**North Carolina Department of Health and Human Services**  
**Division of Public Health**

August 3, 2020

RE: Tropical Smoothie Cafe  
1546 NC Hwy 24/87  
Cameron, NC 28326

This letter acknowledges review of the plan for the above remodel of the referenced establishment. The original plan dated 03/05/2020 and specifications are approved with the following comments:

A4.1

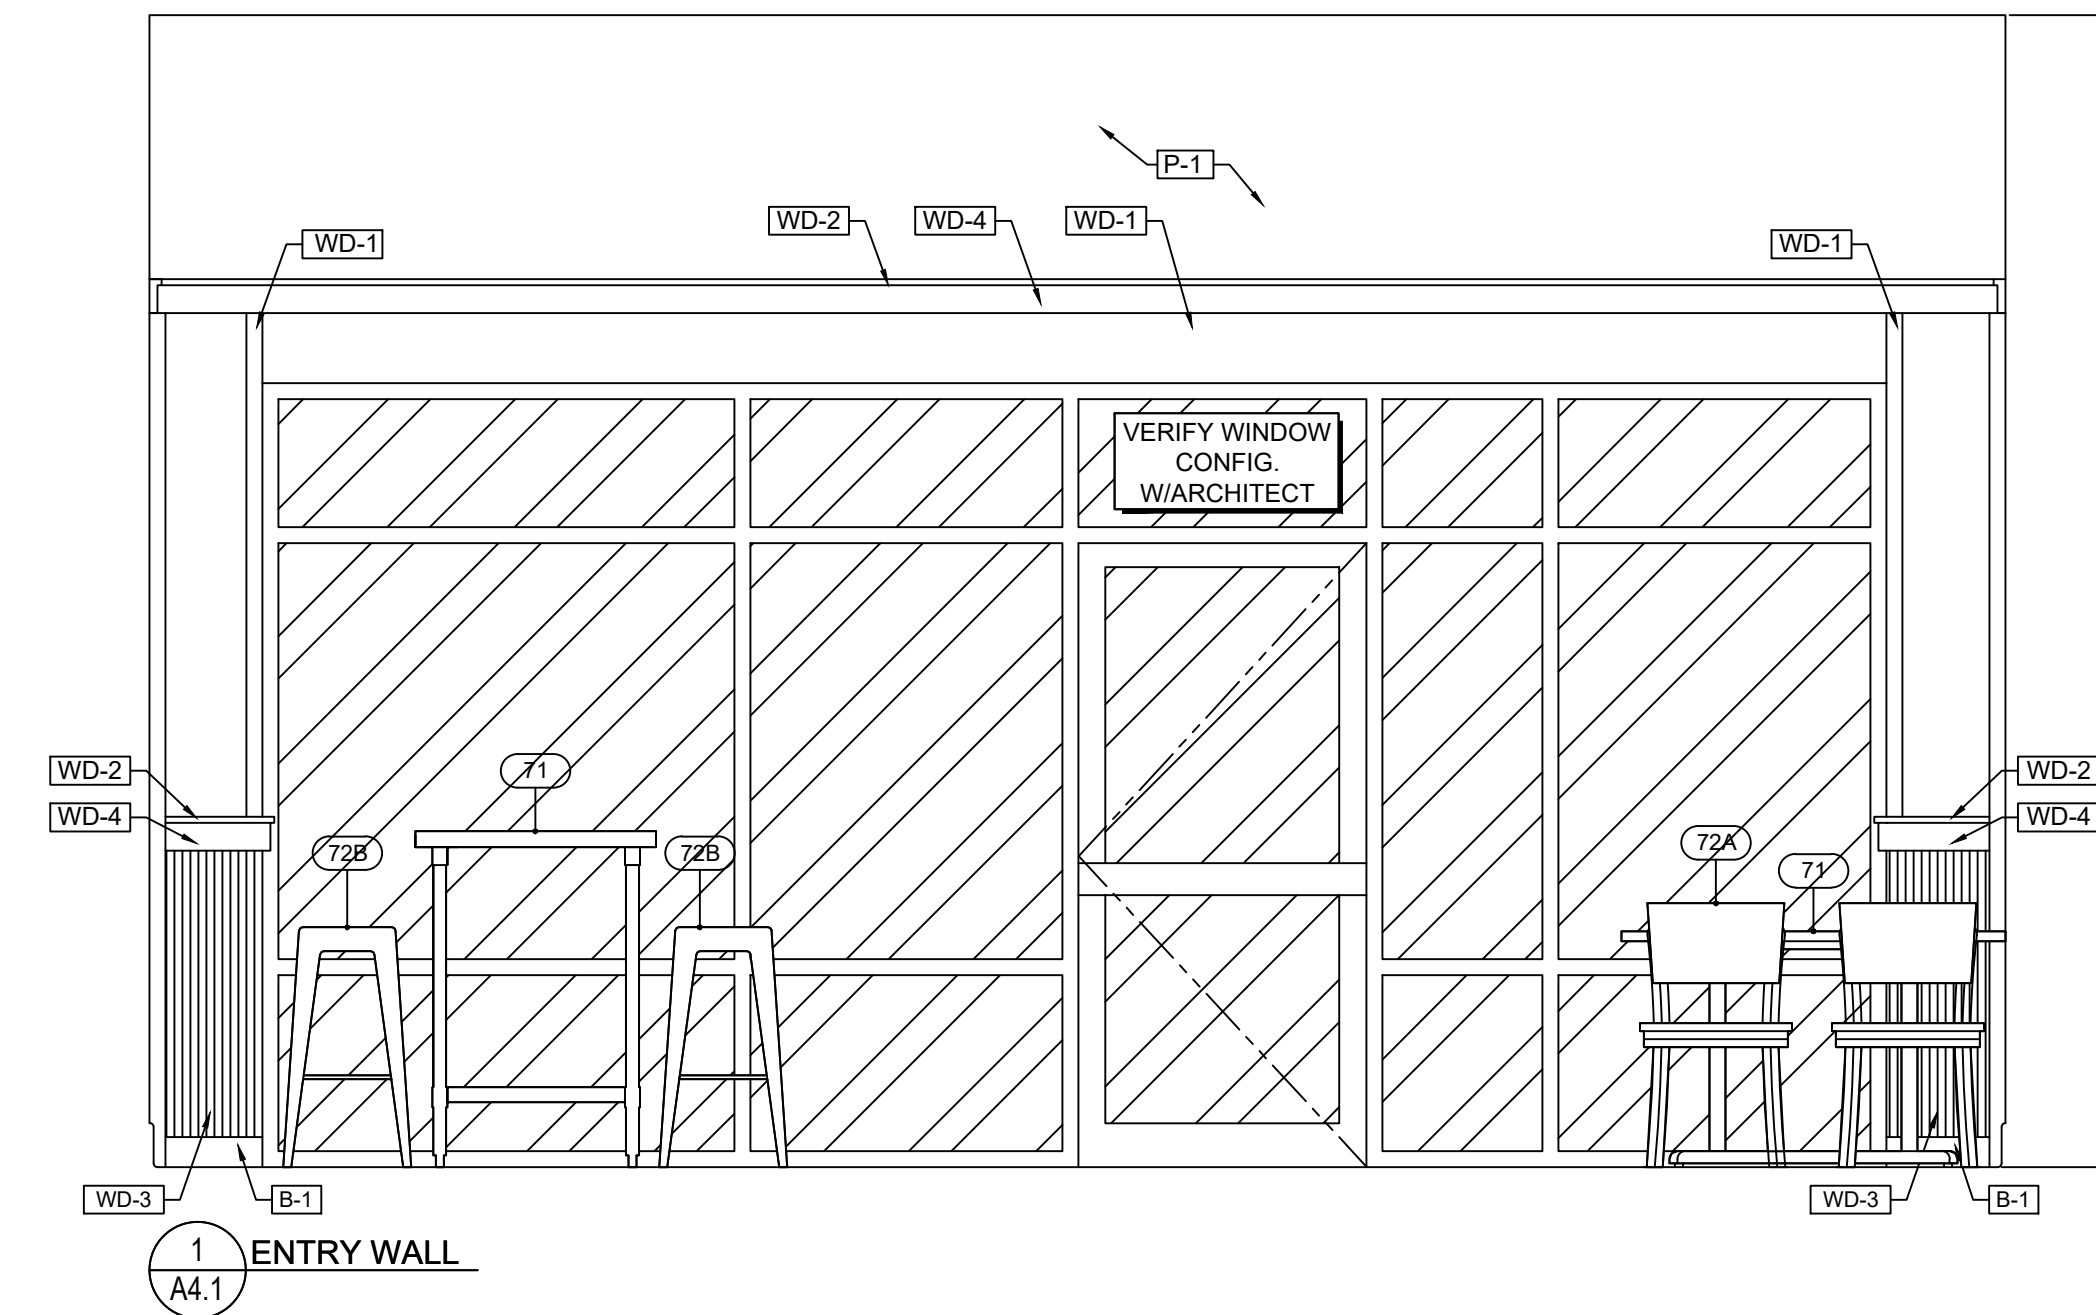
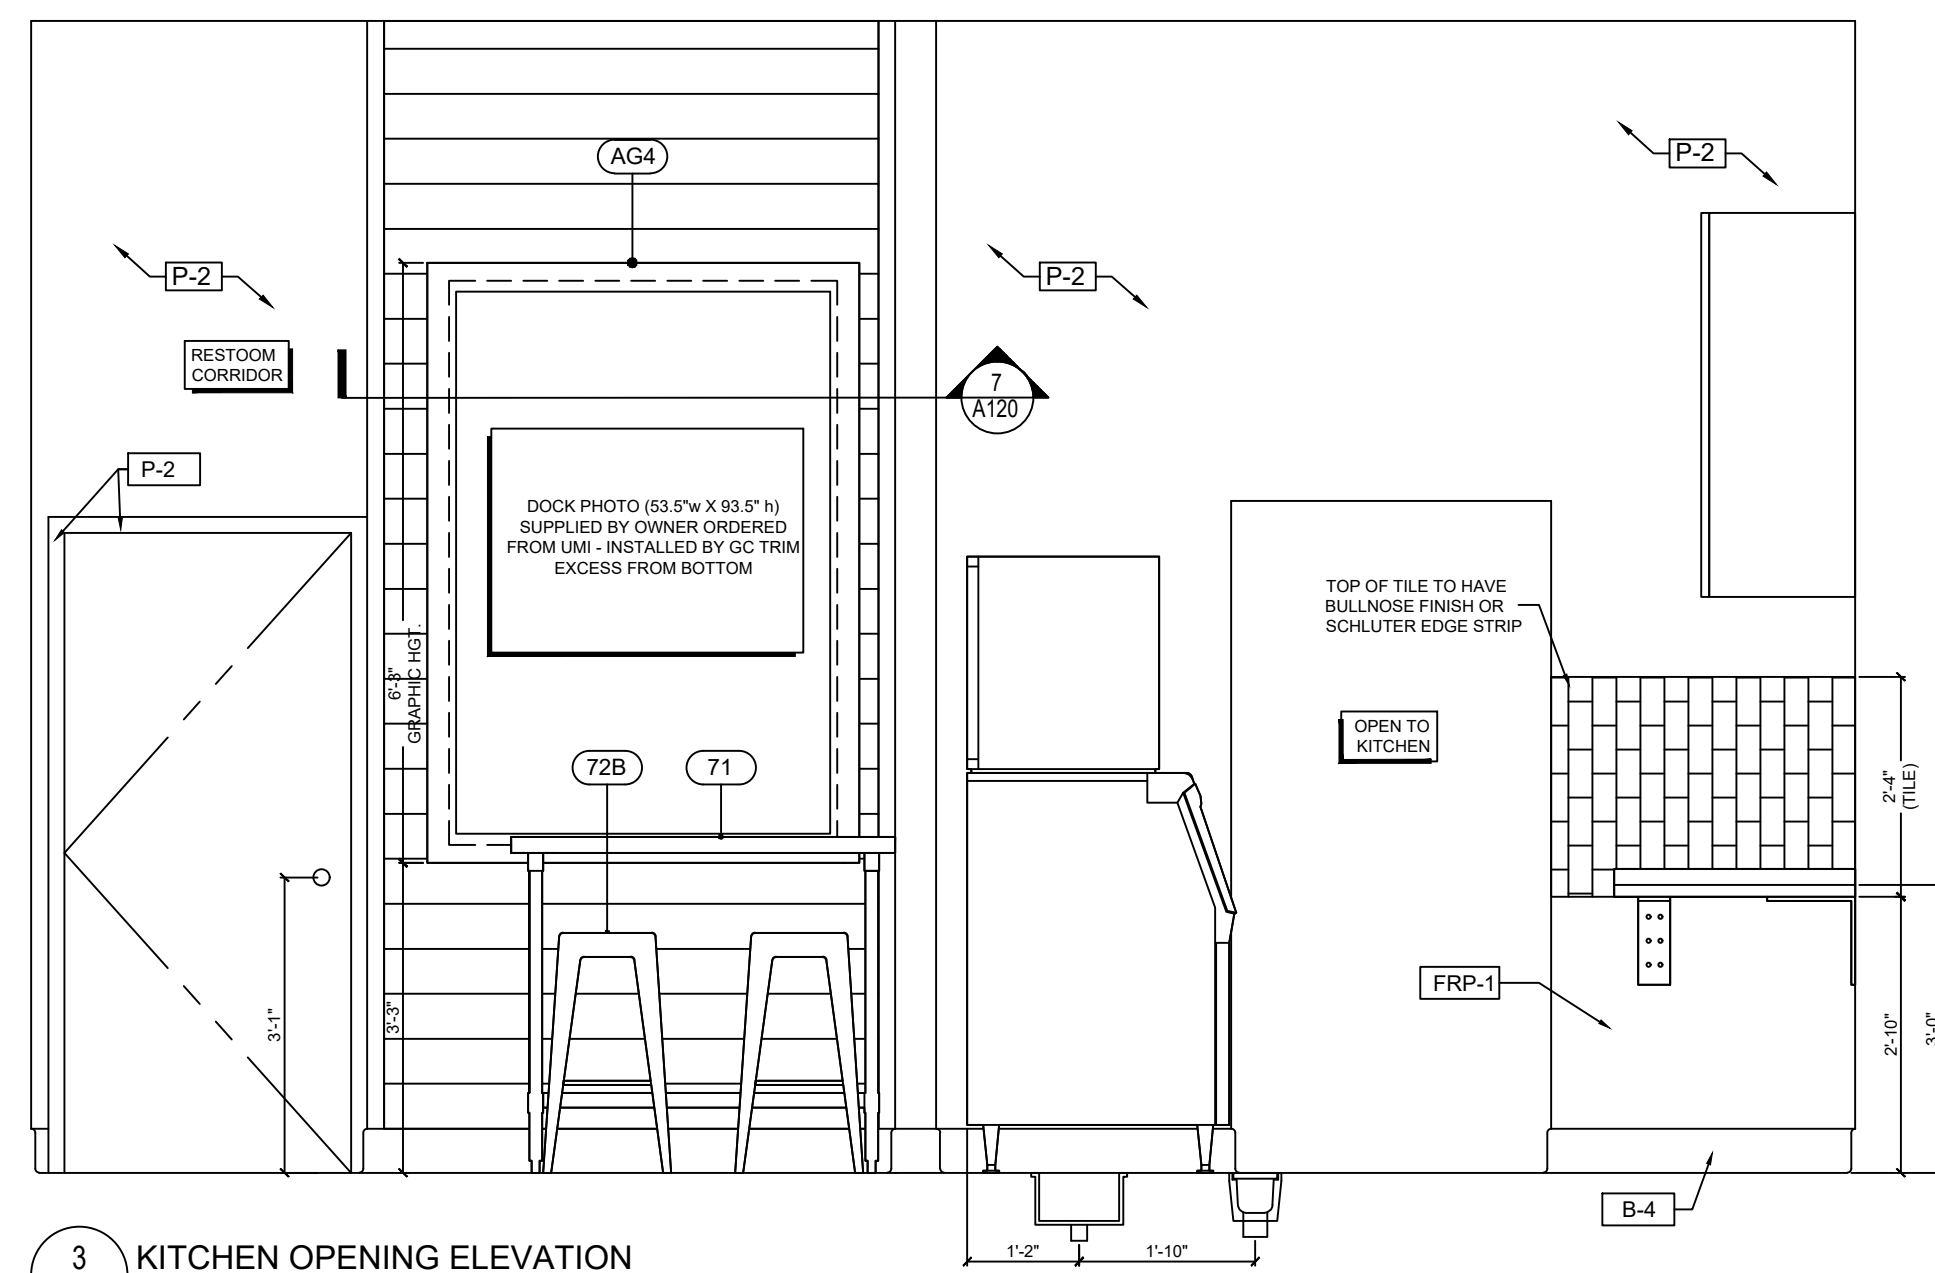
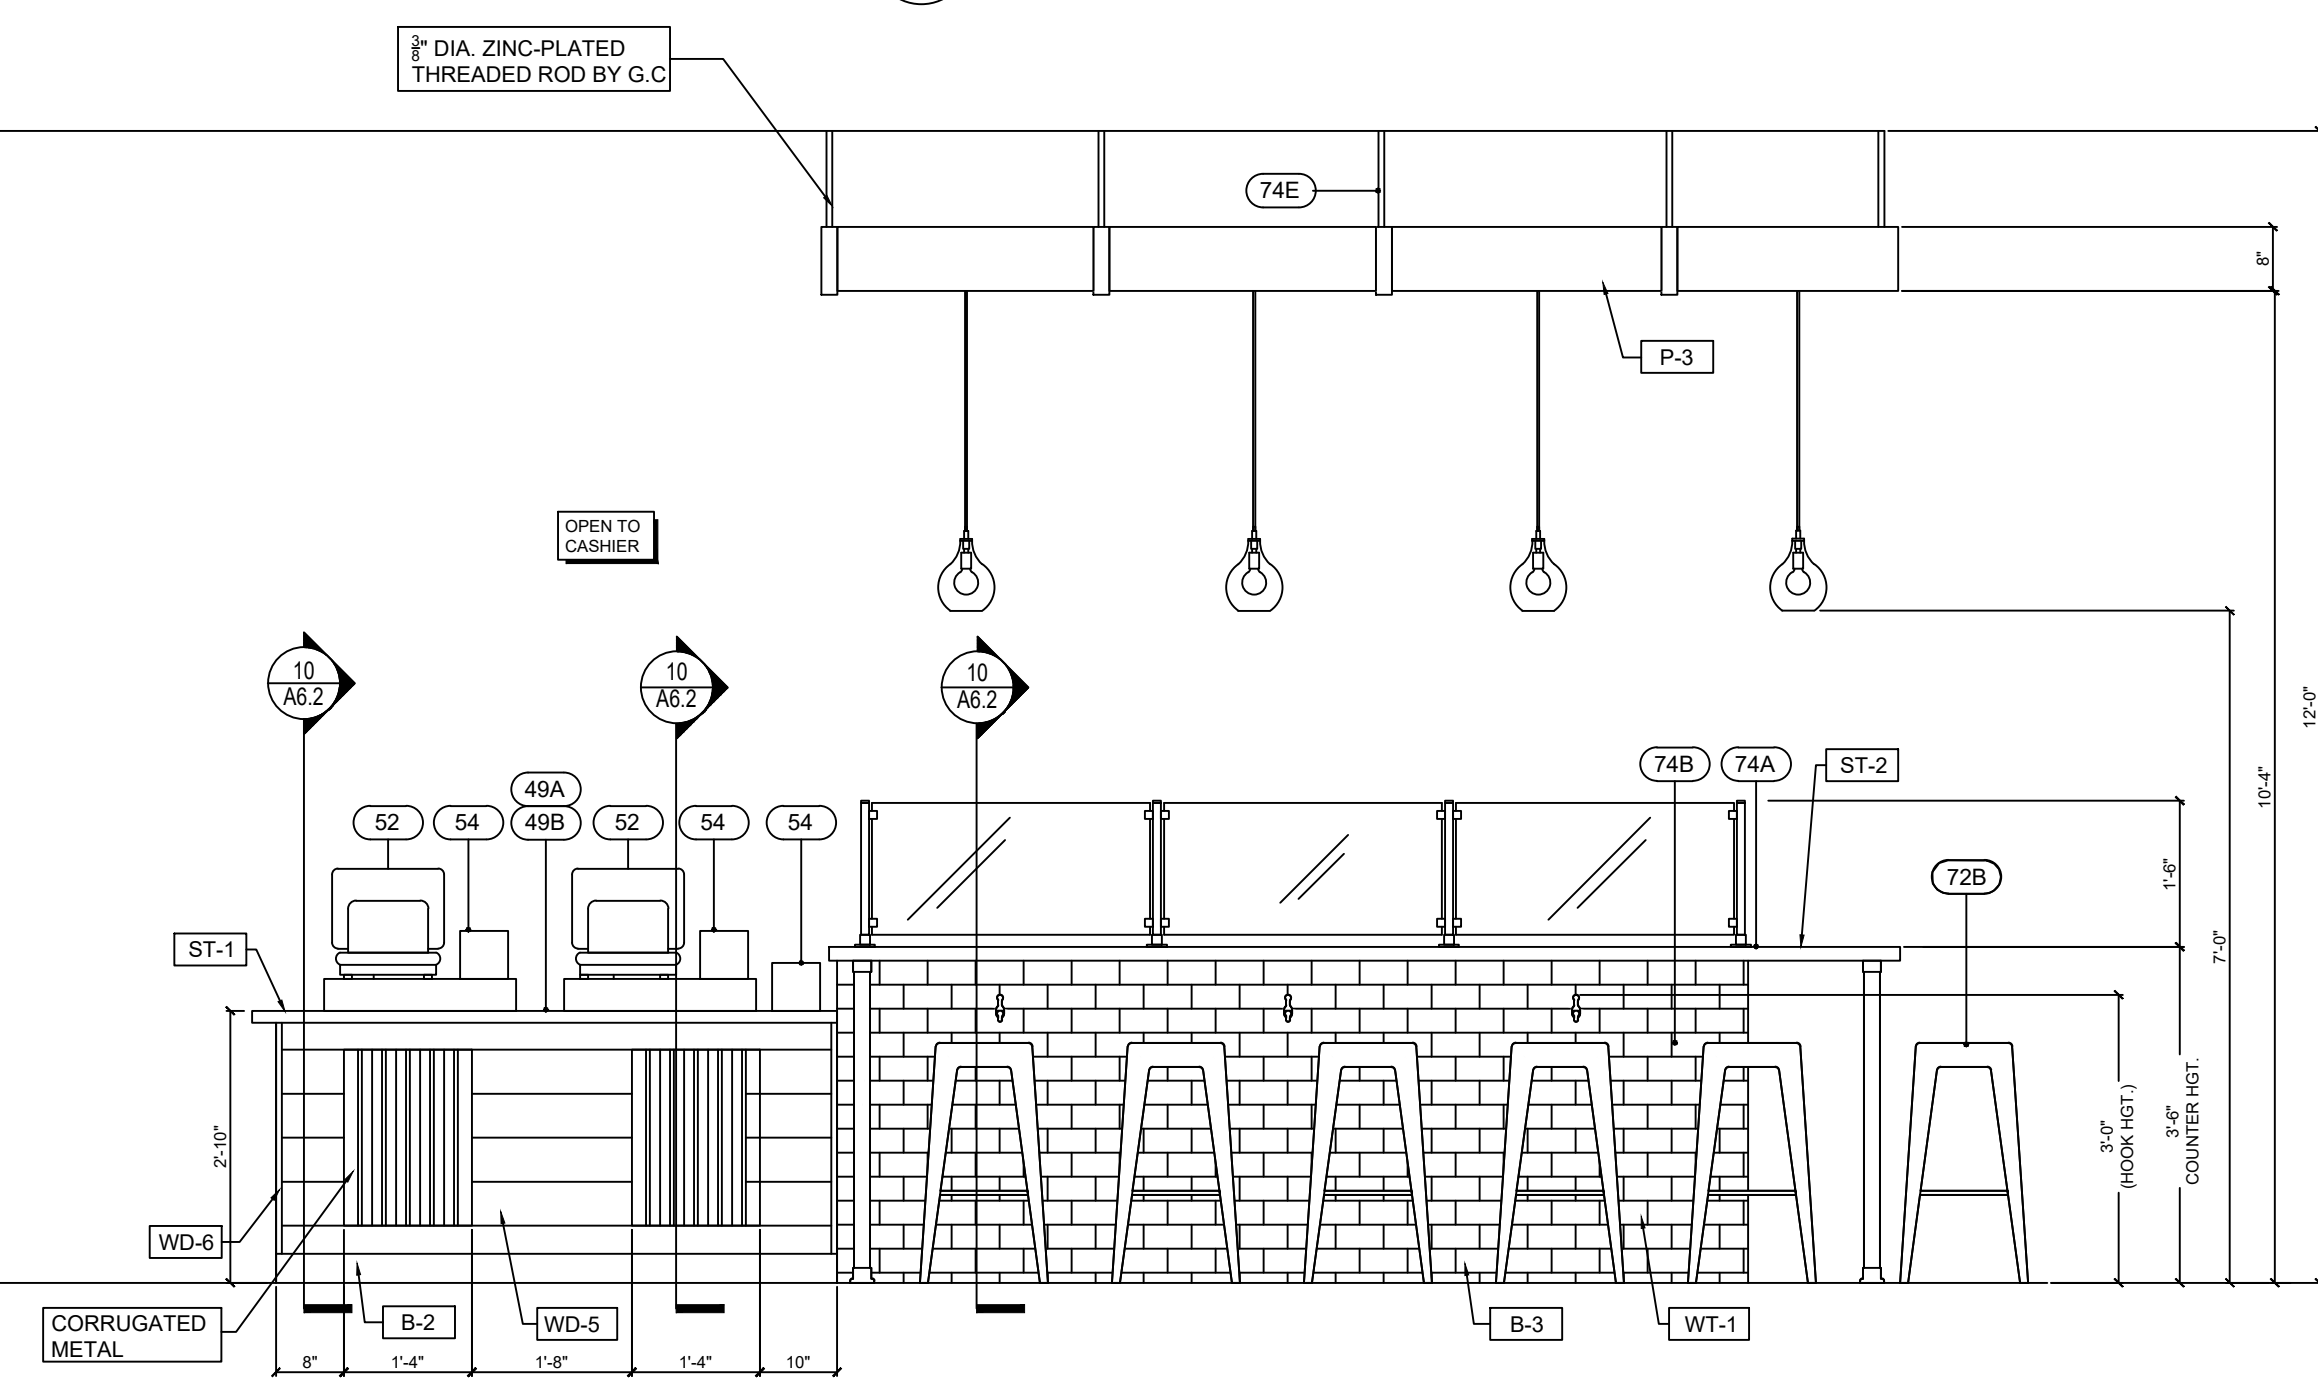
2. Splash guards will need to be installed where there is a concern for sink splash to prevent potential contamination.  
Sneeze guards will be installed as shown on elevation plan sheets 4.0 and 4.1, and on the Equipment Plan sheet A5.0.  
A covered waste receptacle will need to be provided for the disposal of sanitary napkins to meet NC Food Code requirements.
